From: Zac Denton
Sent: 04 April 2018 16:08
To: [REDACTED]
Subject: AW/44/18/HH

I have been looking over your current application that you have with Arun District Council at Lawnswood, Dark Lane, Aldwick.

Project/Address	Side Extension & reconfiguration Lawnswood, Dark Lane Aldwick West Sussex, PO21 4AJ	DRAWING	Proposed Plan
		Drawing No/rev	C9/0126/05
		Scale	1:100 @ A3
		Date	January 2018

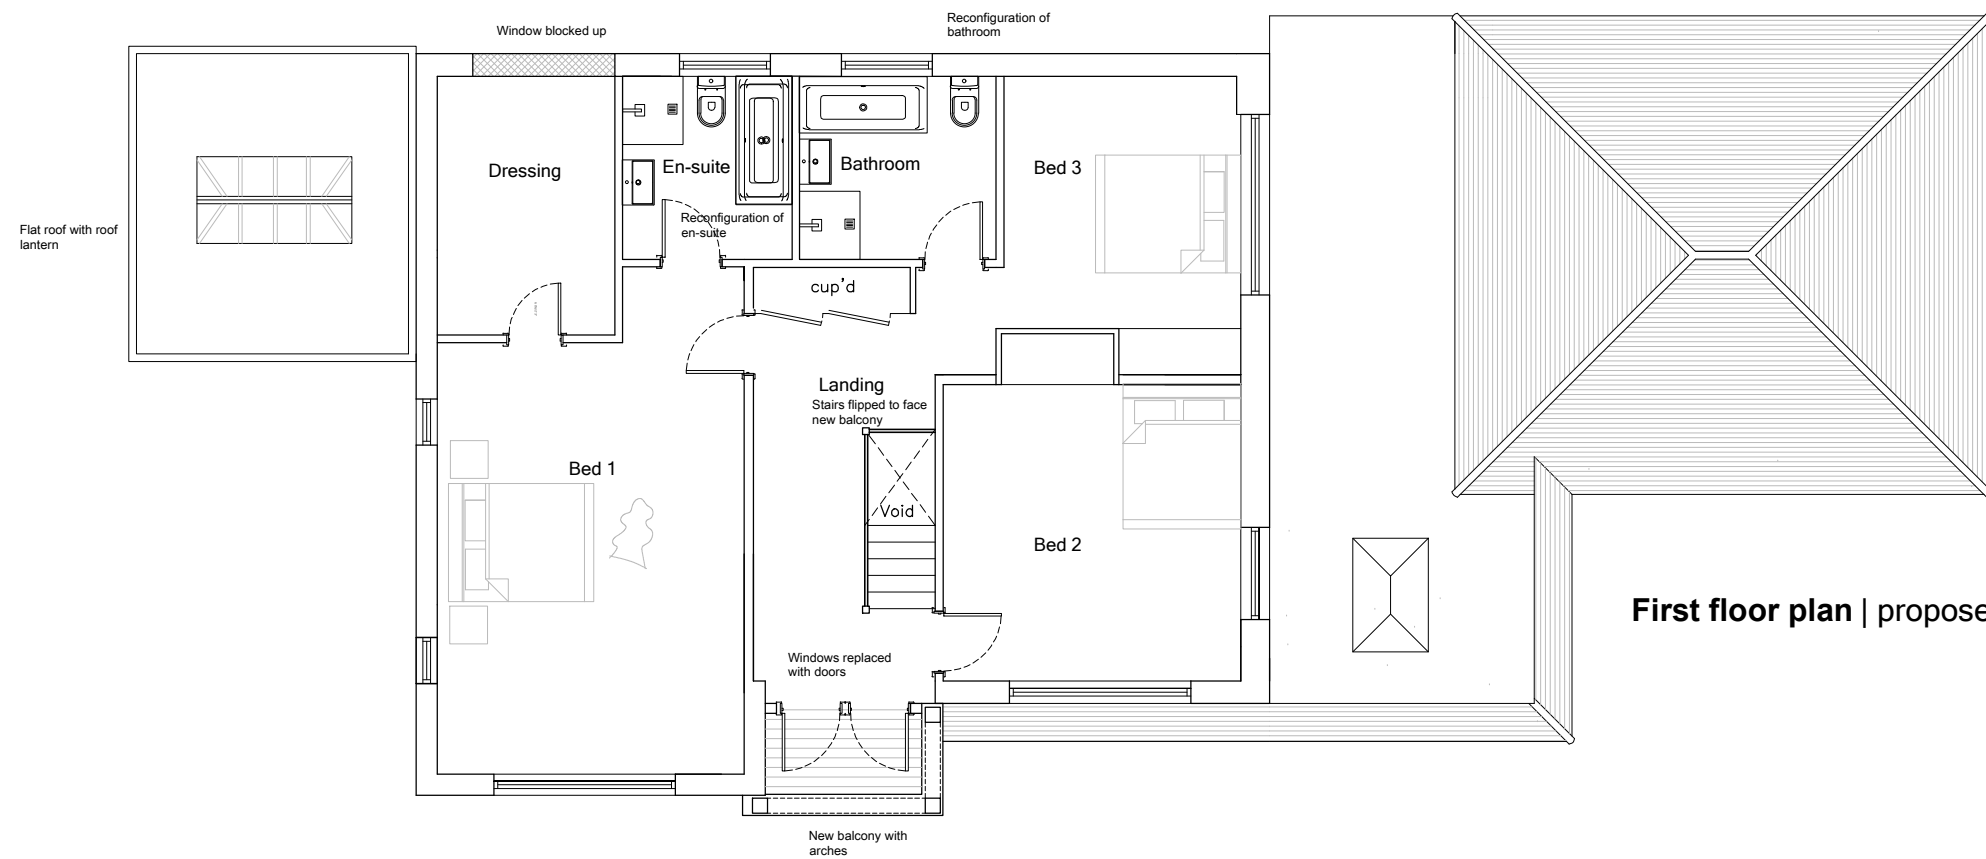
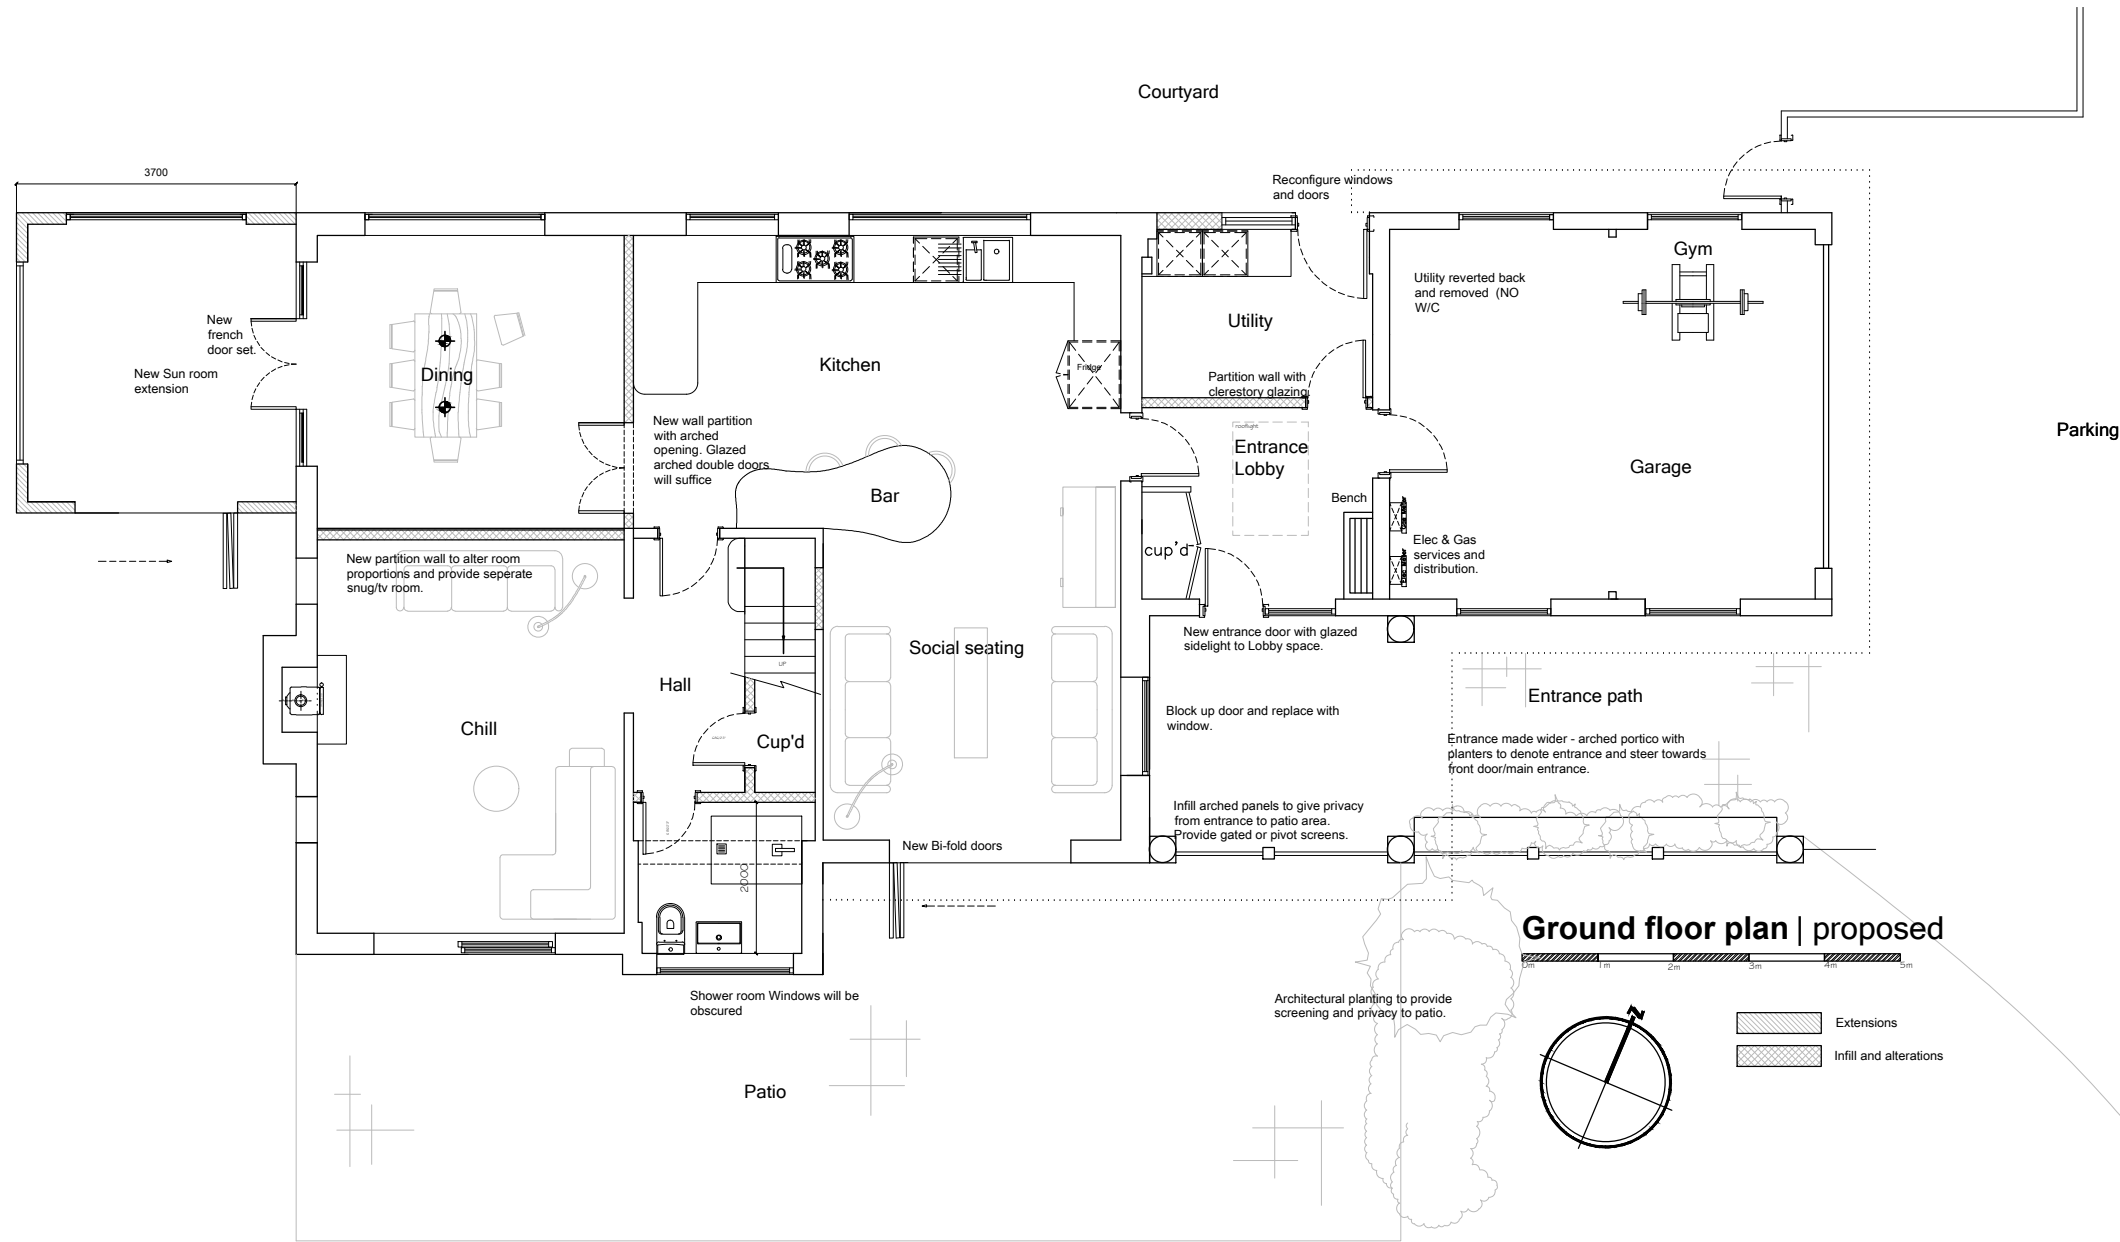
I have found that the majority of the proposal is acceptable, however, I am having some issues with the proposed carport. It is currently 4m high, with a pitch roof, would you be open to a proposal to potentially lower the height of the roof? What about if the roof were to be made a single pitch/cat slide roof?

If not, would you considered removing the carport from the application? This would allow the rest of the application to be approved while negotiations relating to the carport continue.
